**From:** [Jeremiah Cromie](#)  
**To:** ["Dustin Pierce, PLS"](#)  
**Cc:** ["broseburg@hotmail.com"](mailto:broseburg@hotmail.com)  
**Subject:** RE: BL-21-00013 Roseburg Request for Location of Well and Drainfield near house site  
**Date:** Tuesday, June 22, 2021 2:42:00 PM

**From:** Jeremiah Cromie  
**Sent:** Tuesday, June 8, 2021 4:34 PM  
**To:** 'Dustin Pierce, PLS' <[dpierce@encompasses.net](mailto:dpierce@encompasses.net)>  
**Subject:** BL-21-00013 Roseburg Request for Location of Well and Drainfield near house site

RECORD OF SURVEY
 A PORTION OF THE NE 1/4 OF SECTION 3 AND
 A PORTION OF THE NW 1/4 OF SECTION 2
 TOWNSHIP 19 NORTH, RANGE 15 EAST, W.M.,
 KITTITAS COUNTY, WASHINGTON

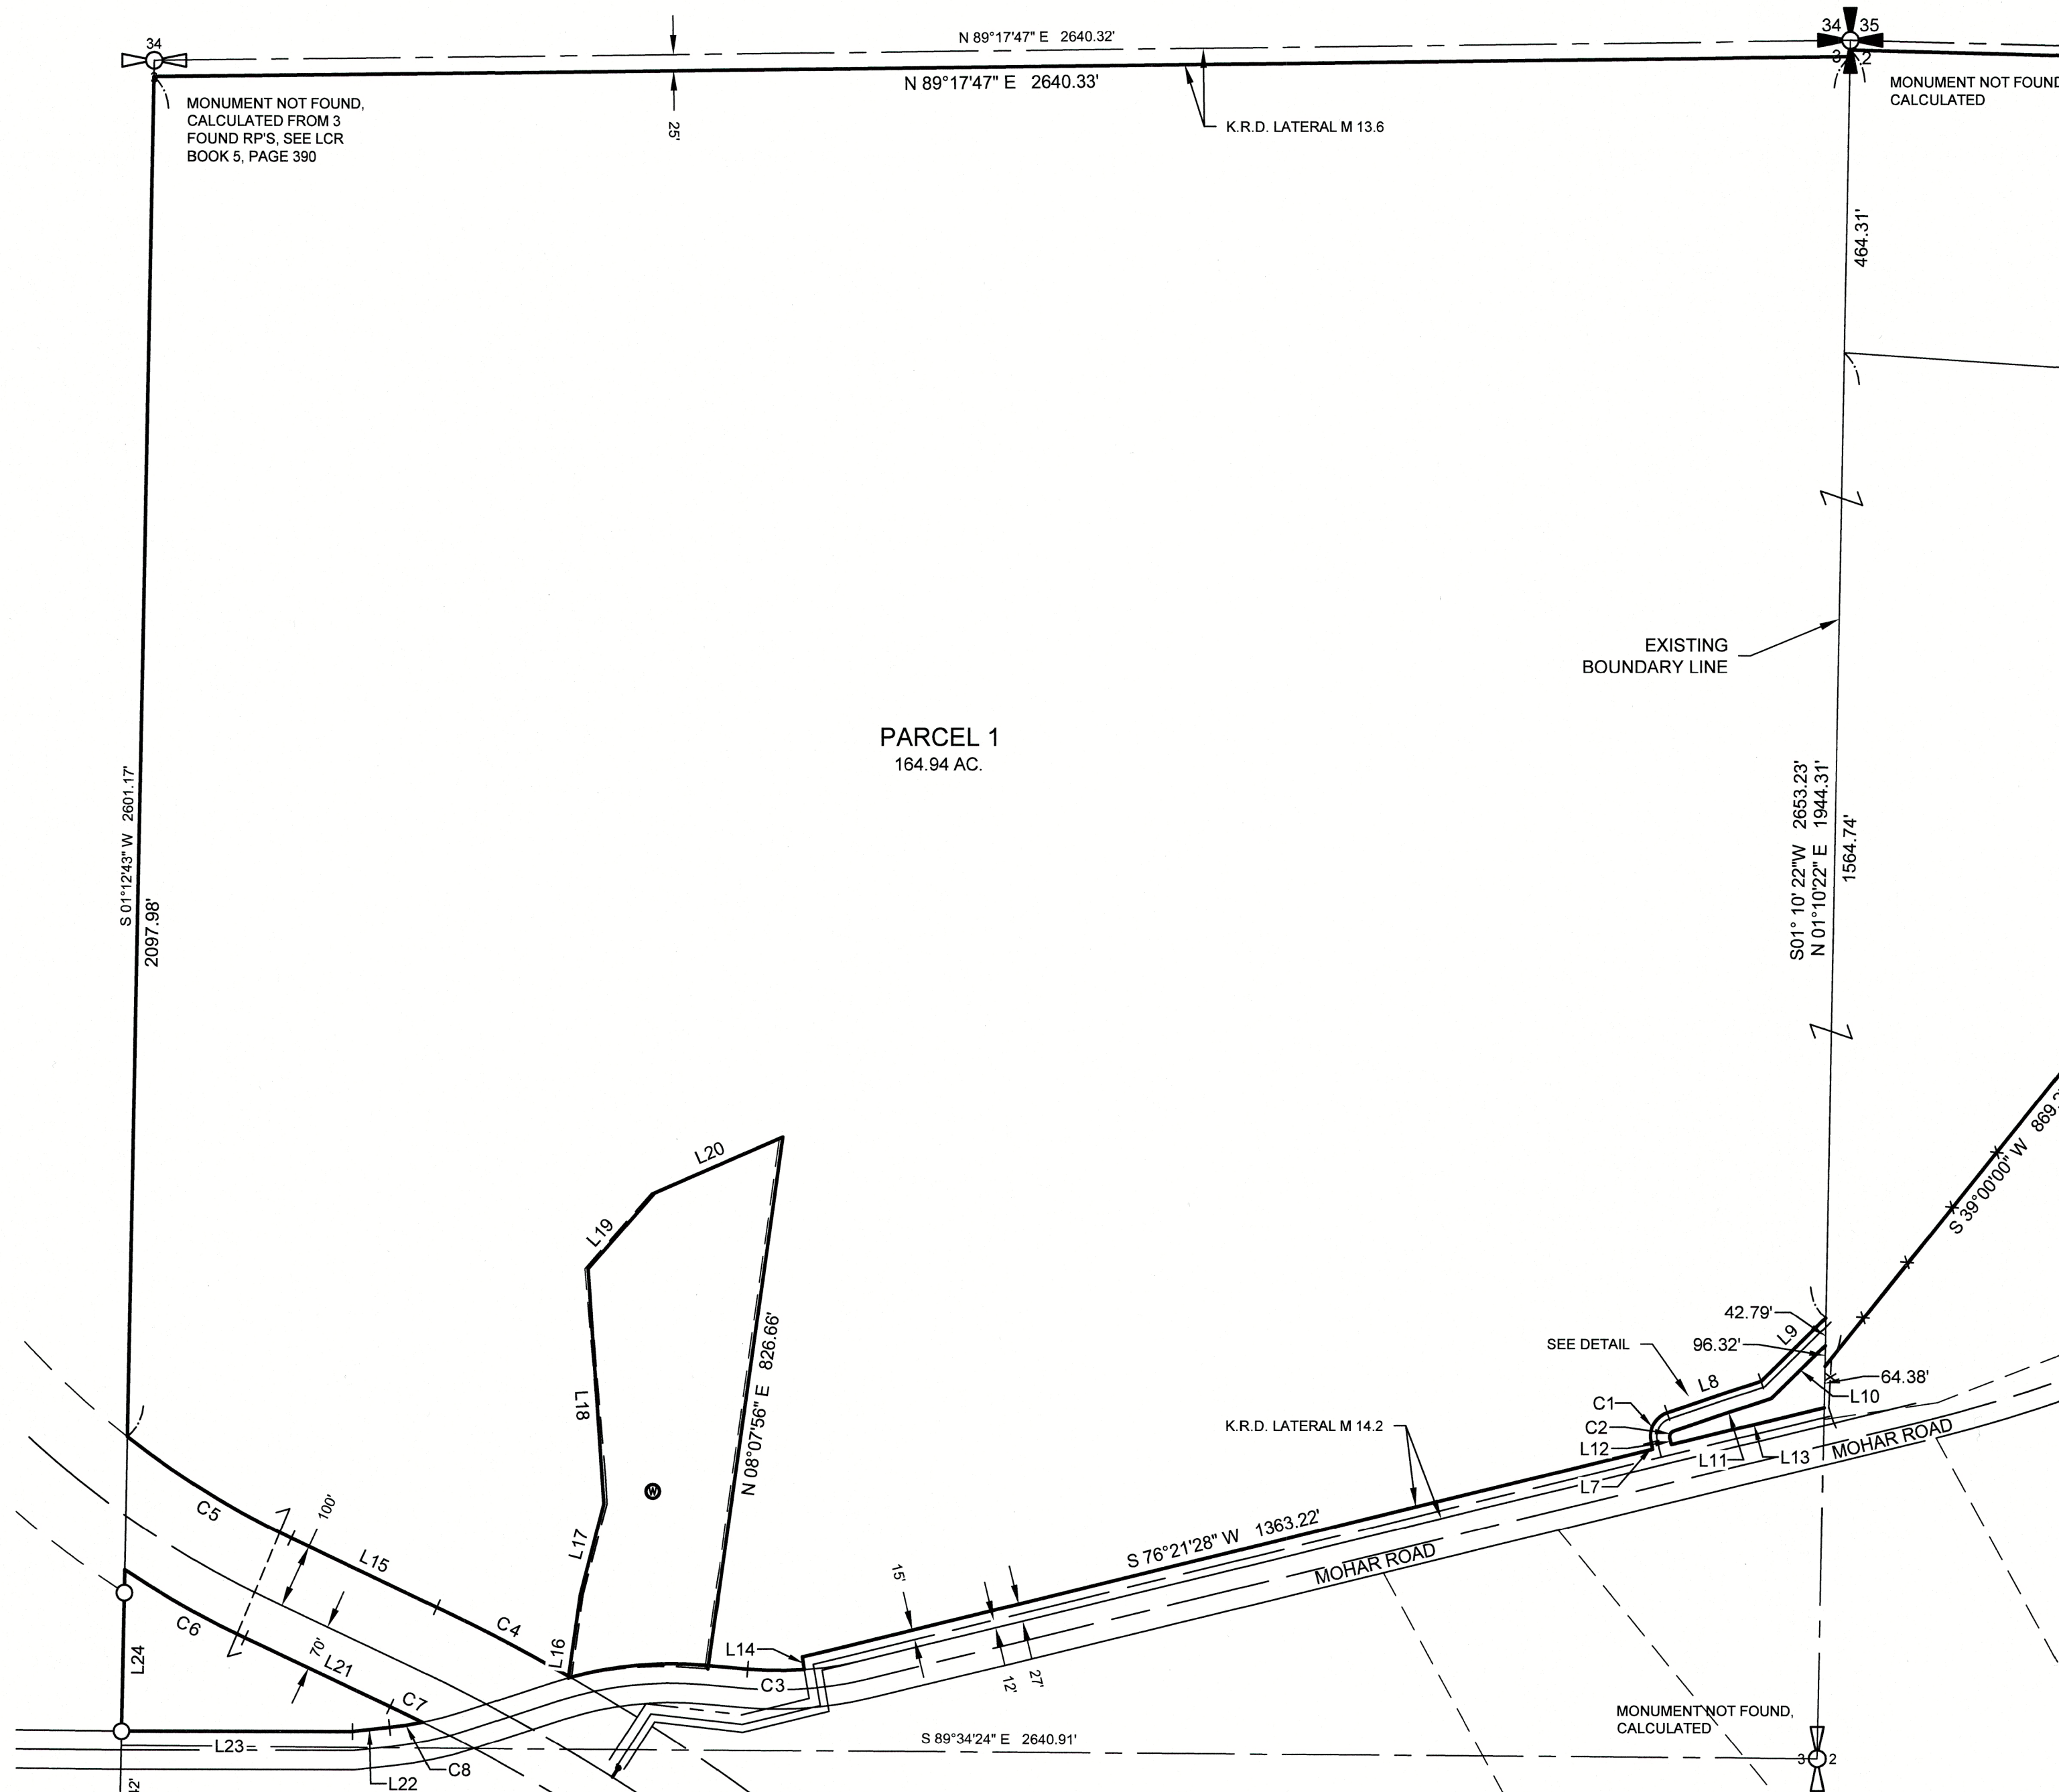
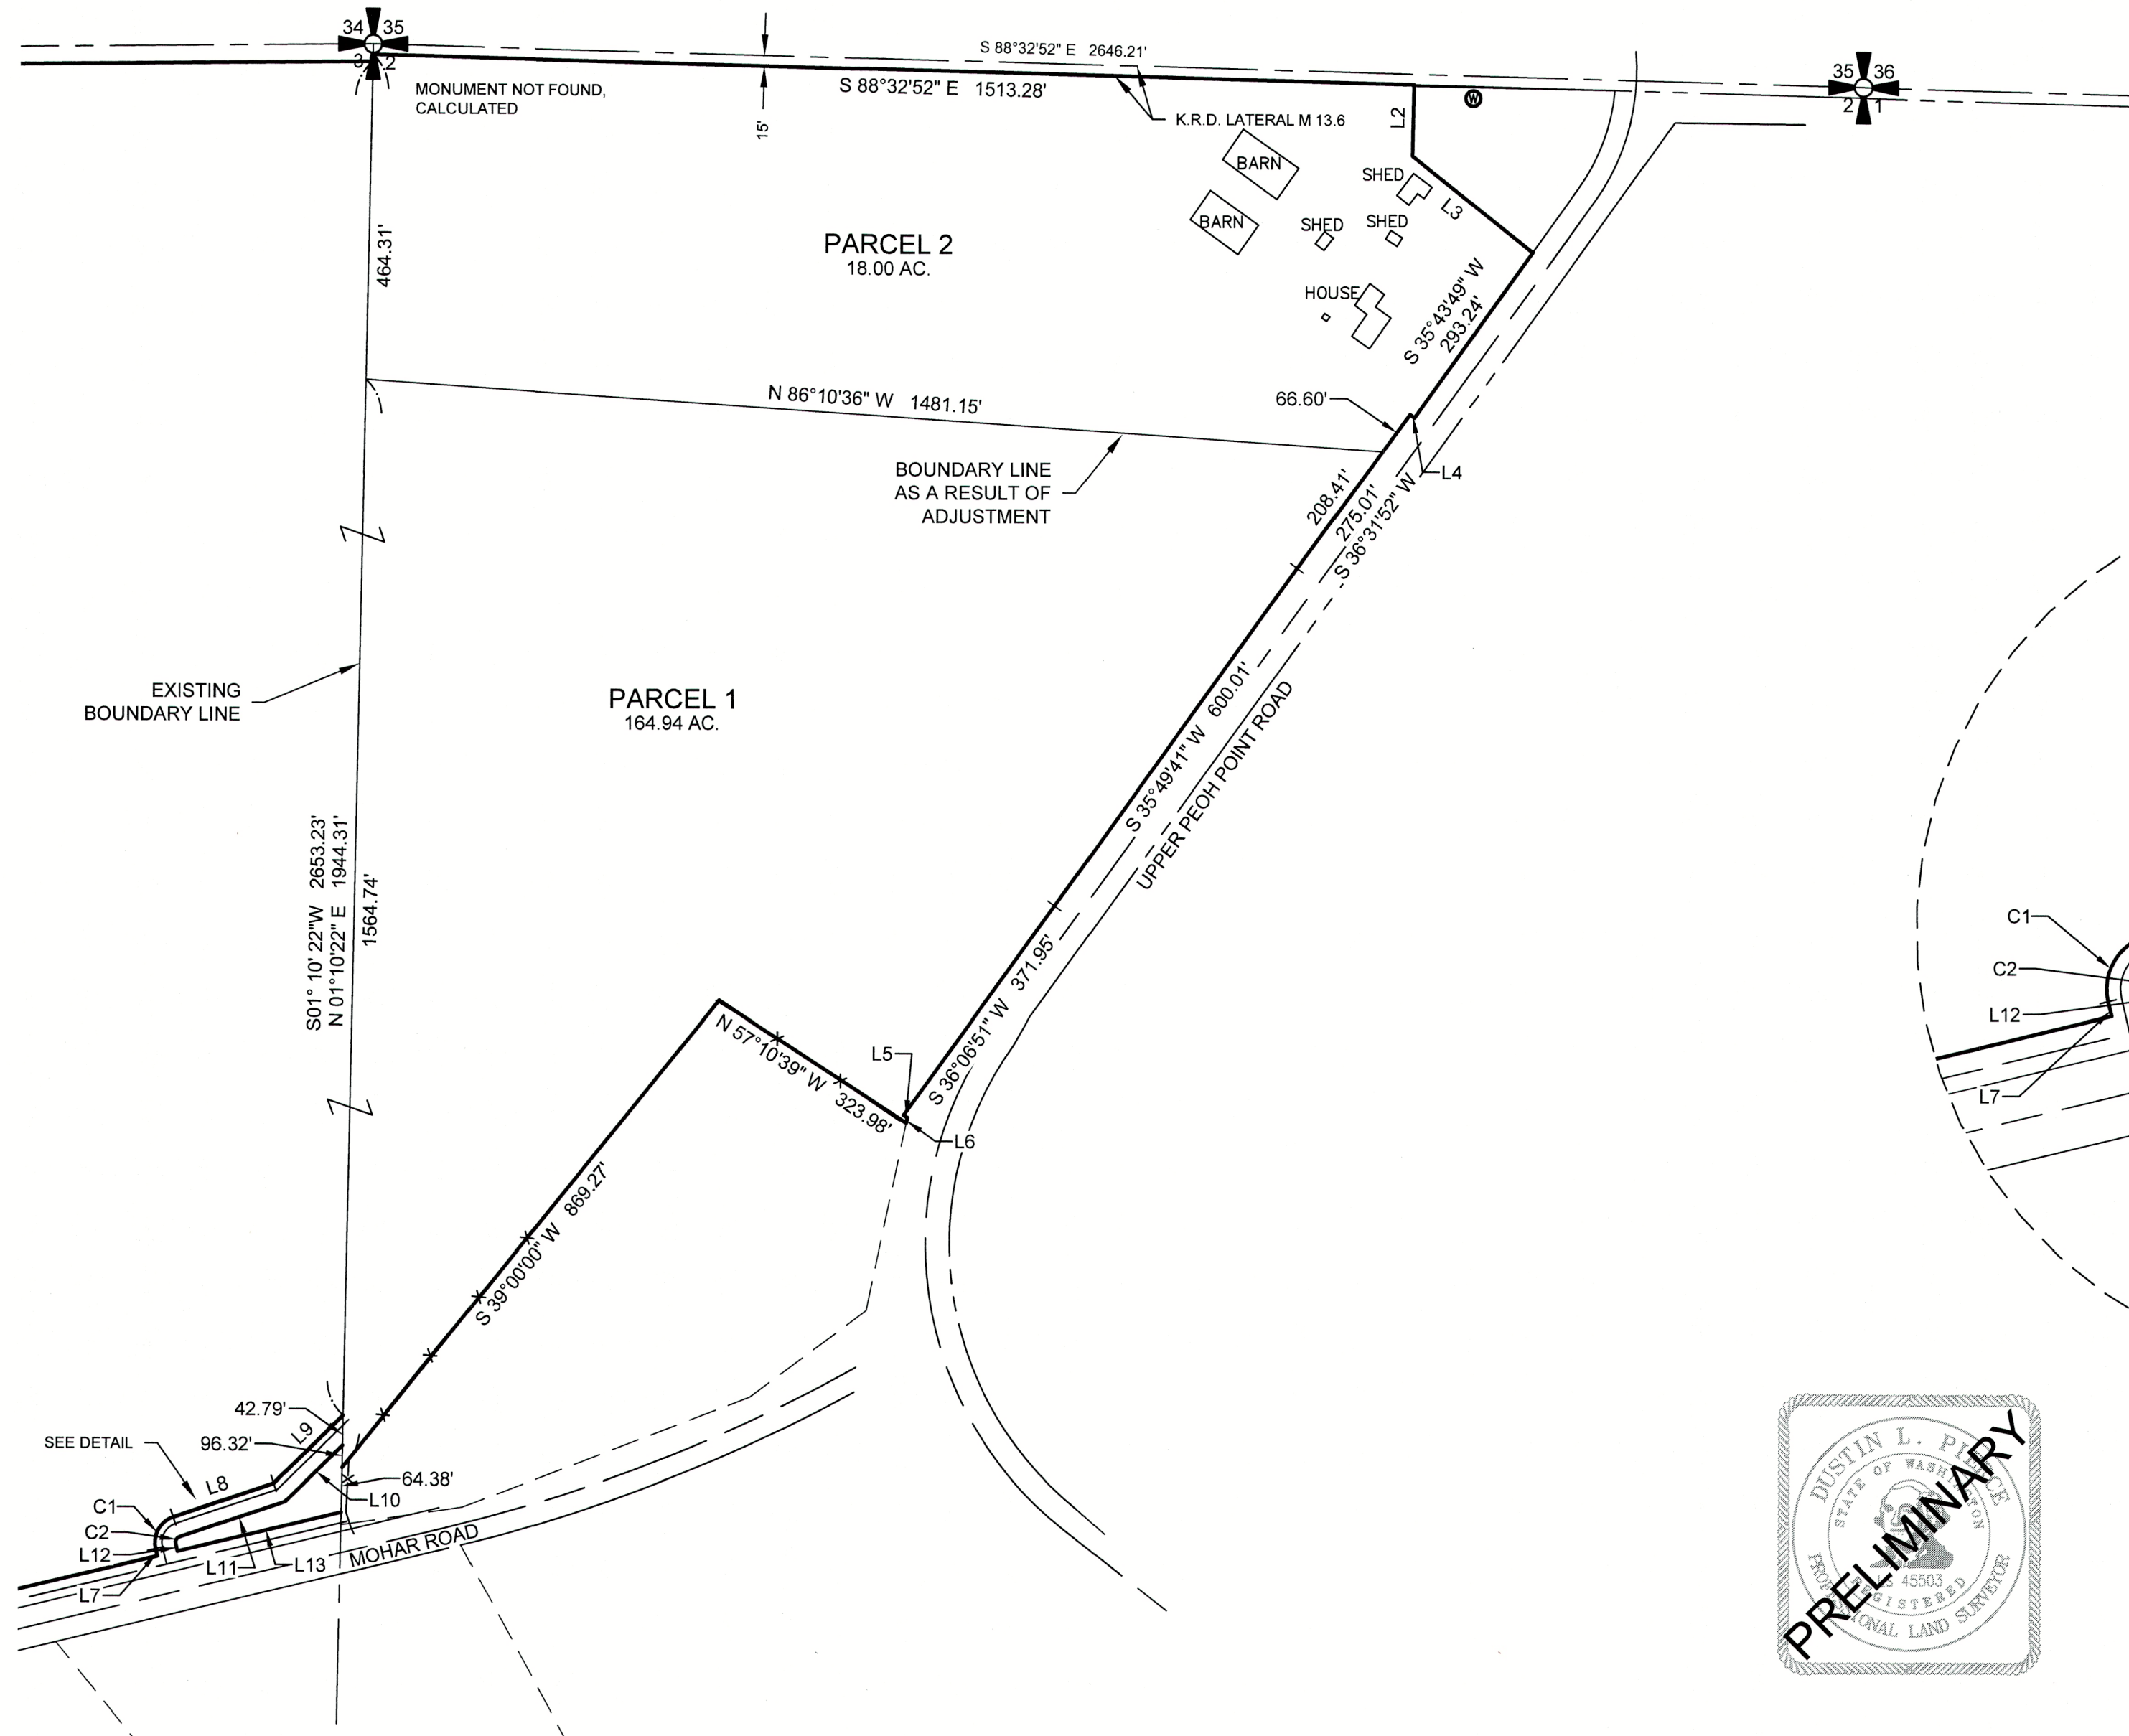
Public Health is requesting to know where the location of the well and drainfield are near the house currently on the property to make sure that they will meet all setback requirements and complete their comments. Can you provide a location for these (possibly on an updated survey)?

The project narrative mentioned individual well and drainfield. Is the little box on the current survey behind the house the well? I have attached the site plan that was submitted with the application for reference.
